September 23, 2008

Subject: Western Pacific Timber, LLC; segregation
Parcel # 19-17-36040-0001
US 97, MP 140.97-142.08

Parcel #: 617934
Legal: Section 36 T19NR17E

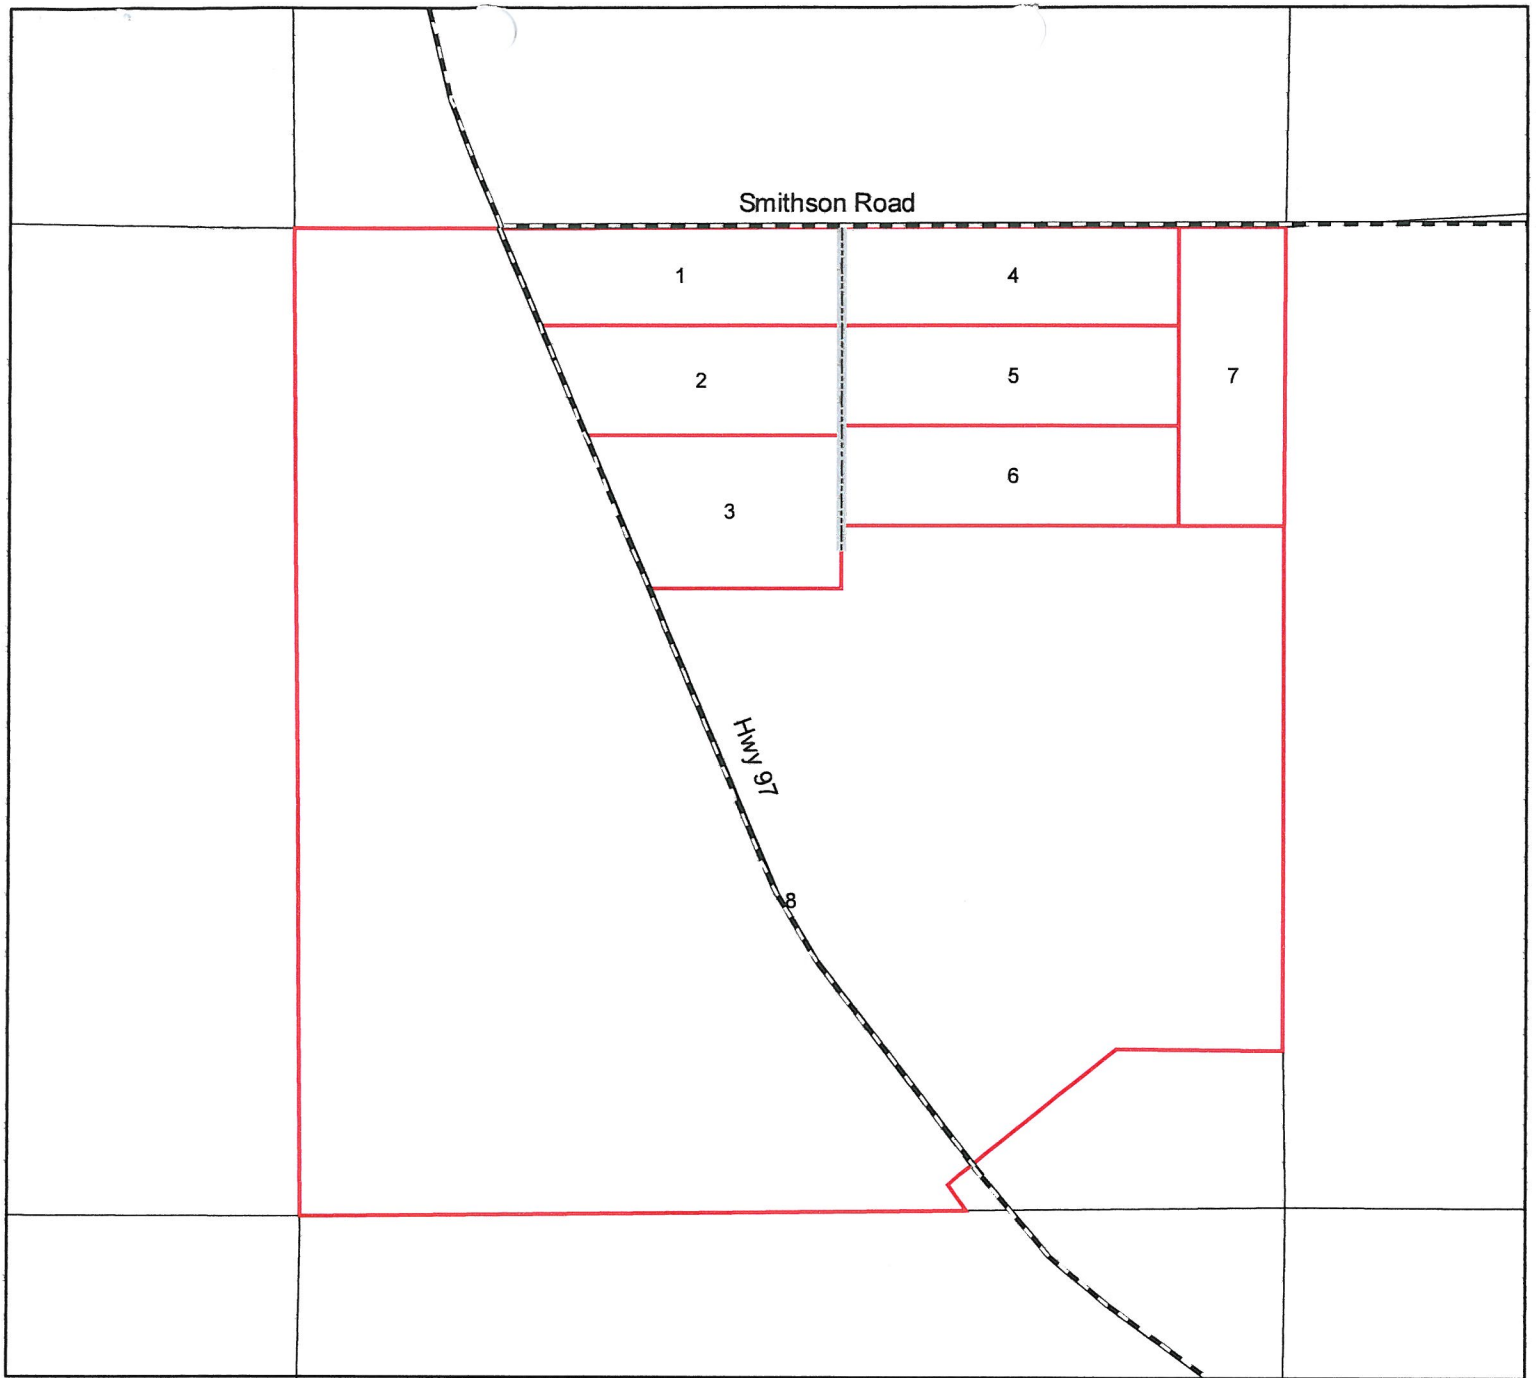
The subject property has frontage along both Smithson Road and US97. US97 is a Class 1 access managed highway with a posted speed limit of 65 miles per hour. Class 1 highway's require access to be made to the county road and, contiguous properties under the same ownership may only have one approach. The minimum spacing between approaches on a Class 1 highway is 1320 feet. There is a single permitted approach at milepost 140.97 on the east side of the highway which is at the southernmost end of the property. There are no approaches to this property on the west side of the highway. For this segregation, all access is required to be to Smithson road as shown on the attached exhibit. Direct access to US 97 for lots 1-3 will not be permitted. We encourage the proponent to contact WSDOT to discuss their future access needs from US97.
